DATE	10-16-13	JOB NO.	08180
ATTENTION	Jeff WATSON		
RE:	B. Proctor Short PLAT SP-08-58

RE: Proctor Short Plat (SP-08-00058)

SUBJECT: B Proctor Short Plat SP-08-00058

B. PROCTOR SHORT PLAT
A PORTION OF THE SE 1/4 OF SEC. 12, T2N, 17N, R9E, 19E, W.M.
KITTITAS COUNTY, WASHINGTON

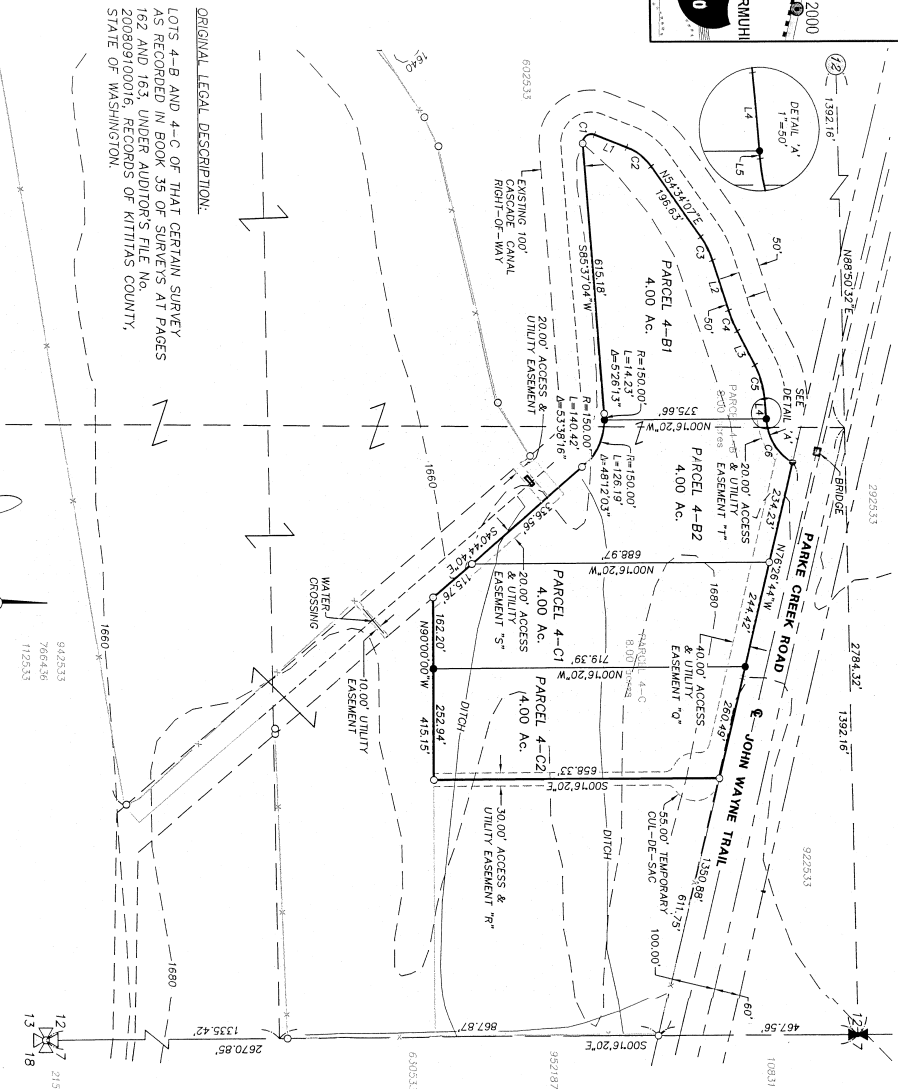
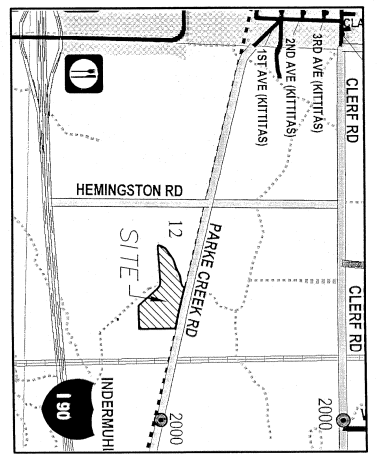
1. Both sheets of the final mylars shall reflect short plat number SP-08-00058 and an accurate legal description shall be shown on the face of the final plat.

4. The following plat notes shall be recorded on the final mylar drawings:
 - All development must comply with International Fire Code.
 - This short plat has exhausted the use of the one time split provision allowed per Kittitas County Code. No further one time splits are allowed for the subject parcels and subsequent parcels created via this short plat.

6. A statement regarding the contemplated sewage disposal, water supply, and drainage improvements for the proposed subdivision shall be reflected on the final mylars.

8. Individual wells are required to have a 50 foot setback from neighboring property lines (KCC 17A.08.025). Please see the comments from Kittitas County Public Health Department for further information and requirements.

12. Per Kittitas County Environmental Health, soil logs need to be performed and proof of water availability is needed. Evidence of both shall be provided to Community Development Services prior to final approval.
